ORICA BOTANY

CAR PARK WASTE ENCAPSULATION
REMEDIATION PROJECT – PROJECT
APPROVAL 06_0197
MODIFICATION 6 – RESPONSE TO
SUBMISSIONS

01 OCTOBER 2015

CLIENT: ORICA.	PROJECT: CARPARK NO 3. WASTE ENCAPSULATION PROJECT.
DATE: JULY 2015 DWG. NO. 15-007/L02	SCALE: 1:500 @ A1 NO. IN SET 3

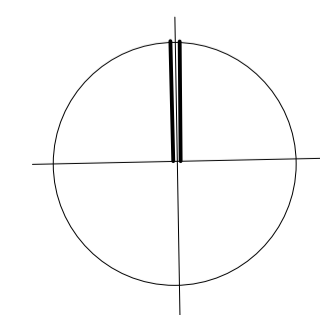
Item	Department of Planning and Environment – 8 September 2015	Orica response
1	Please provide a plan which shows both the trees that Council has approved for removal and the additional trees that are proposed to be removed. Have the trees under proposed stockpile B already been approved for removal?	<p>There are no trees situated on the proposed Landscape Mound B.</p> <p>The vegetation visible from the aerial photos in this location are small grasses and shrubs that have grown on the second stockpile of validated material (Stockpile B), established during the soil treatment stage of the Car Park Waste Encapsulation (CPWE) Remediation. The soil was subject to hydromulching in 2012 as erosion and sediment control.</p> <p>Stockpile B will be subject to works to allow it to remain in its current location as a permanent landscaped mound (Landscape Mound B). The works include:</p> <ul style="list-style-type: none"> ▪ Placement of material surplus to the spreading and compaction of the main stockpile; ▪ Construction of retaining walls and battering; and ▪ Revegetation. <p>Figures showing the extent of the:</p> <ul style="list-style-type: none"> ▪ area where vegetation clearing has already been approved under DA/486/2010; and ▪ area where further clearing is required under this Proposal (Modification 6) <p>have been included in Annexure B of the revised Proposal.</p>

2	Please provide details of any proposed landscaping.	<p>Following construction, the Proposal Area will be incorporated into a landscape services program. The service includes inspection, watering, reseeding and planting, trimming and snipping on a regular basis. The Landscape Plan is under development. A draft has been provided to the Department separately. The current plan is as follows.</p> <p><i>Destination A</i></p> <p>The spreading and compaction of the main stockpile of validated material (Stockpile A) will occur on Destination A. Destination A will have retaining walls installed, and sections of</p>

<p>battered edges that will be turfed with Kikuyu grass which will be maintained under the aforementioned Landscape Plan. No additional landscaping is necessary for this portion of the works. As the Department is aware, Orica is currently negotiating divestment conditions with an interested party on the land referred to as Destination A, being Part Lot 104 DP 1192400 (a figure has been provided to the Department separate to this response). Any future works and development, including landscaping, shall be managed by the new owner and is separate to this Proposal.</p> <p><i>Landscaped Mounds</i></p> <p>Landscaped Mound B will be timber edged and mass planted with the following shrubs:</p> <ul style="list-style-type: none"> ▪ Acacia Longifolia ▪ Acacia Saligna ▪ Allocasuarina Glauca ▪ Leptospermum Laevigatum ▪ Melaleuca Armillaris ▪ Melaleuca Stypheloides <p>Landscaped Mound C will be turfed with Kikuyu grass.</p>
